CASTLE GROUP

SSD-9472 Sikh Grammar School
Lots 42 & 43 DP30186 151-161 Tallawong Road Rouse Hill

The following forms our submission regarding the above Development Application for a proposed school. We are making a submission on behalf of the adjoining site to the north at 141 Tallawong Road Rouse Hill, in addition to 95 Tallawong Road, 114 Tallawong Road, 105 Cudgegong Road and 119 Cudgegong Road as well as the Rouse Hill Residents Action Group

DRAWING TITLE				
EARTHWORKS GRADING PLAN (STAGE 1)				
PROJECT NO.	PLANSET NO.	RELEASE NO.	DRAWING NO.	REVISION
P1806439	PS05	R04	PS05-C100	D

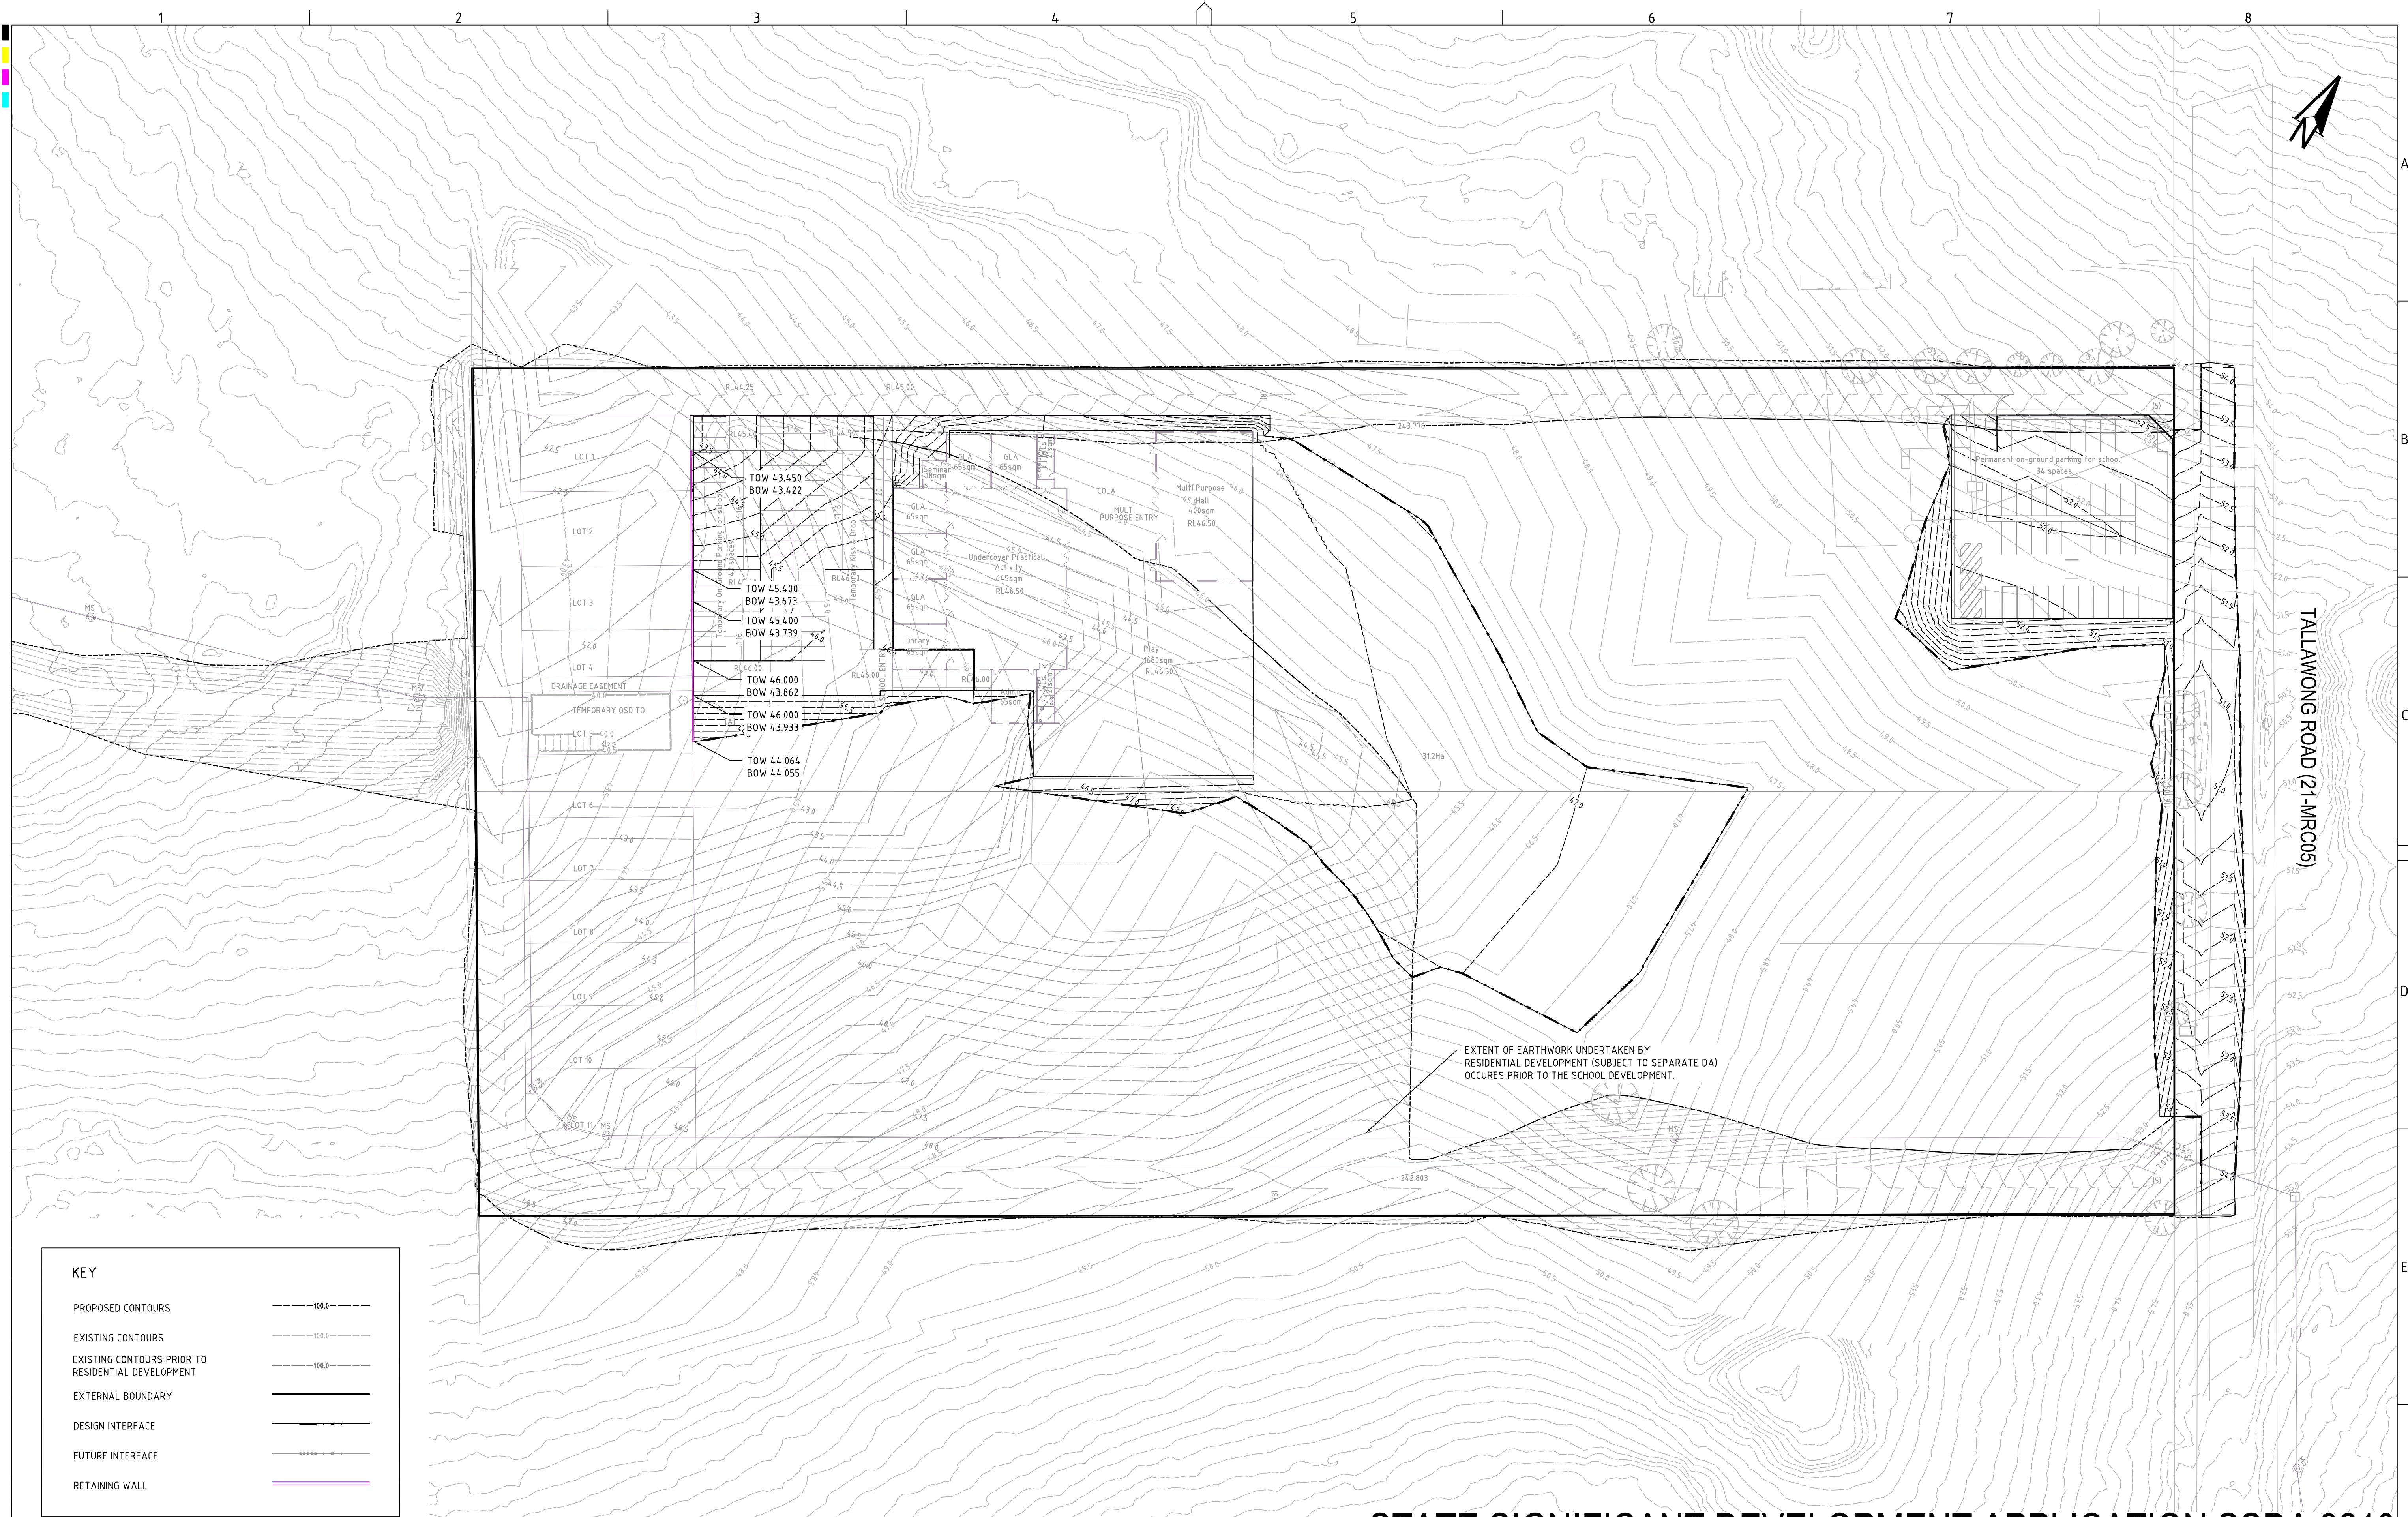
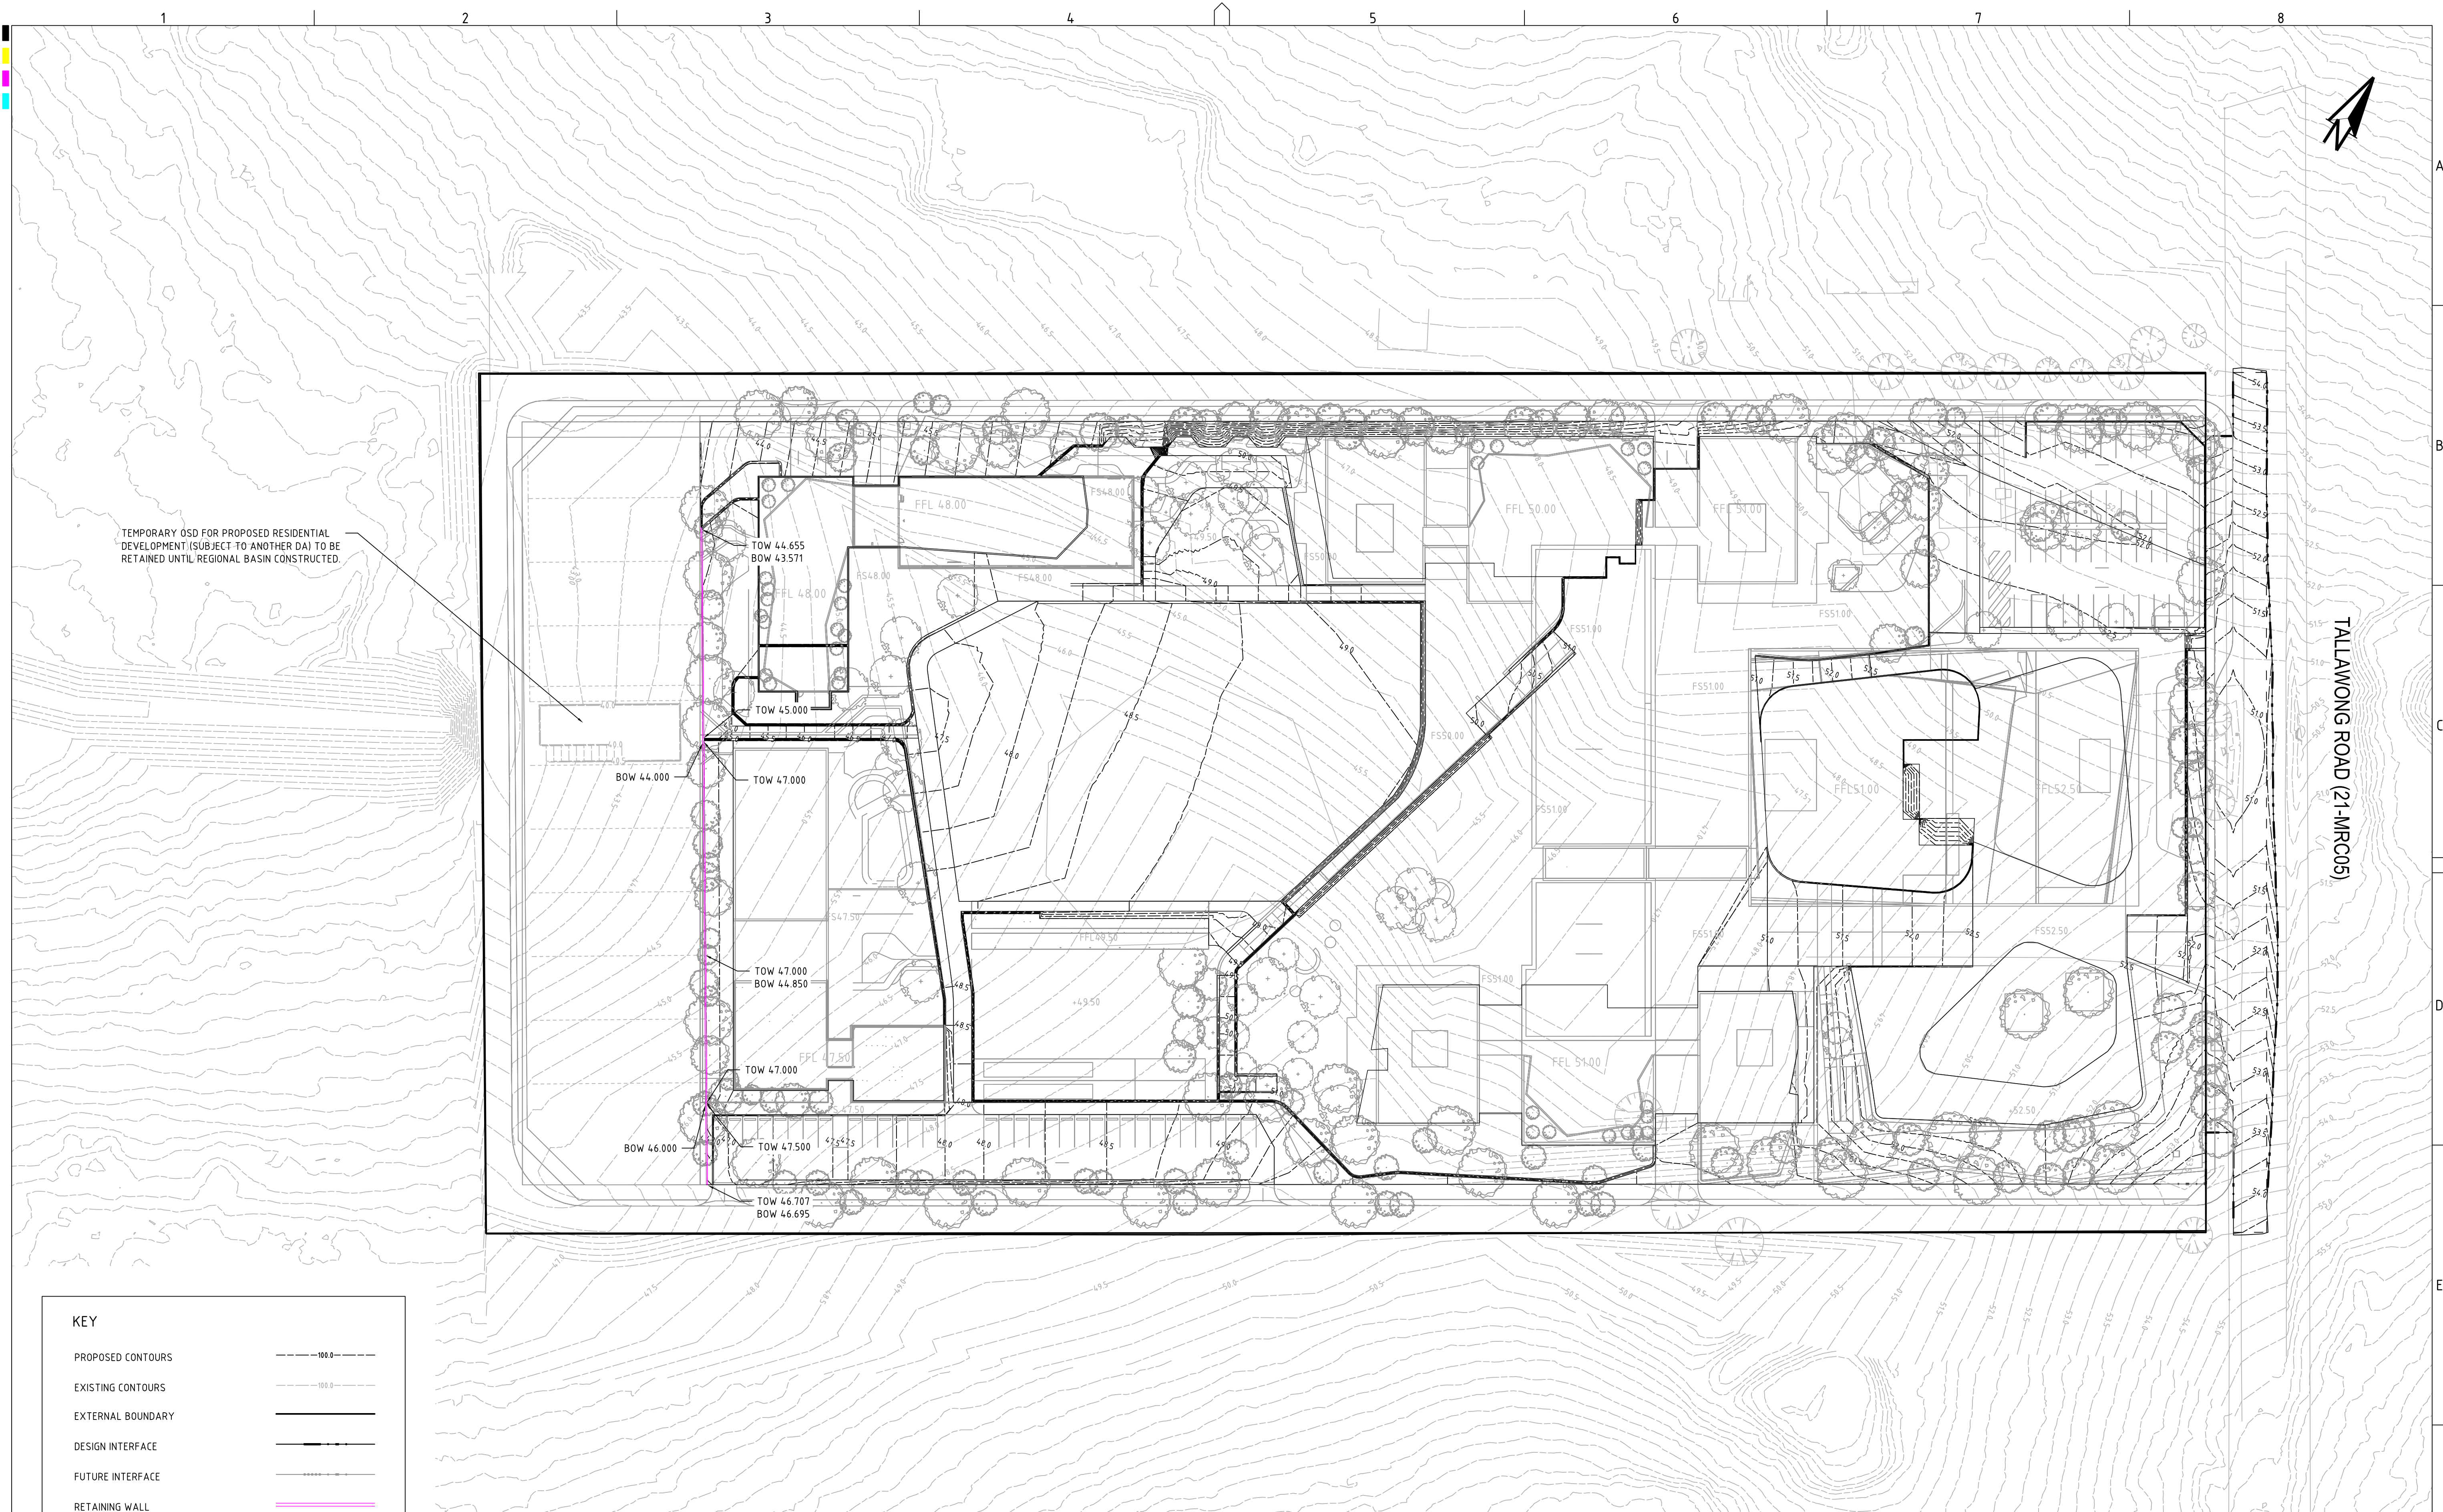
The engineering drawings indicate that there is battering to the adjoining properties to the north, south and west. We have not granted consent for any works to our property (141 Tallawong Road) and therefore the application cannot be approved in its current form.
